**RE: Love's Broadway/Sunport Blvd
3200 Broadway Blvd SE
30-Day Temporary C.O. – Accepted
Engineer's Certification Date: 03/11/2026
Engineer's Stamp Date: 05/29/2025
Hydrology File: M14D038
Case #: HYDR-2026-00096**

Based on the site visit on 03/17/2026, this letter serves as a conditional approval from the Hydrology Section for a 30-day Temporary Certificate of Occupancy for the subject property to be issued by the Building and Safety Division. The following comment needs to be addressed prior to acceptance for Permanent C.O. of the above referenced project:

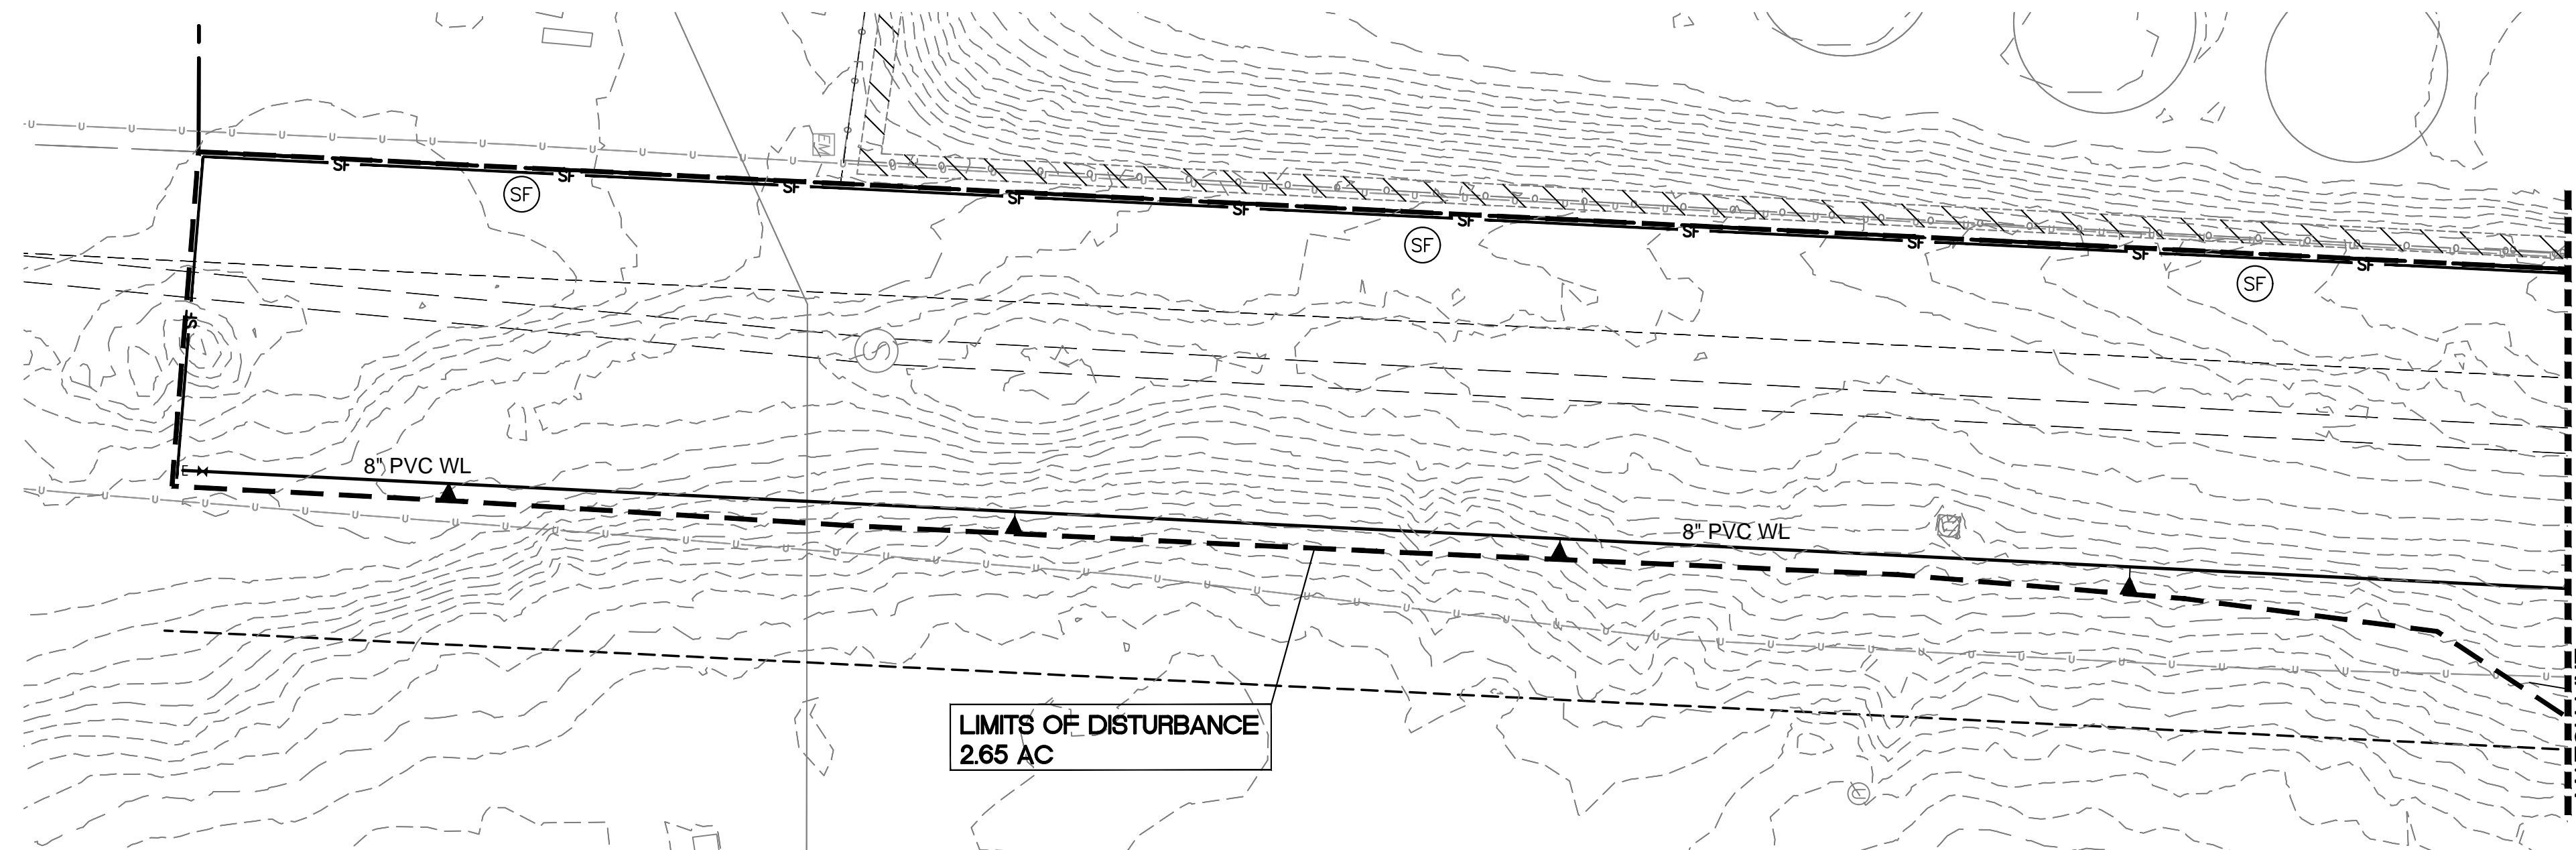
1. Side slopes of ponds need to be stabilized per construction plans and City Standard Spec 1013.
2. Provide the executed paper Drainage Covenant (latest revision) printed on one-side only with Exhibit A and a check for \$25.00 make out to "Bernalillo County" for the stormwater quality ponds per Article 6-15(C) of the DPM to Hydrology for review at Plaza del Sol. Additionally, please submit the Drainage Covenant to ABQ-Plan.
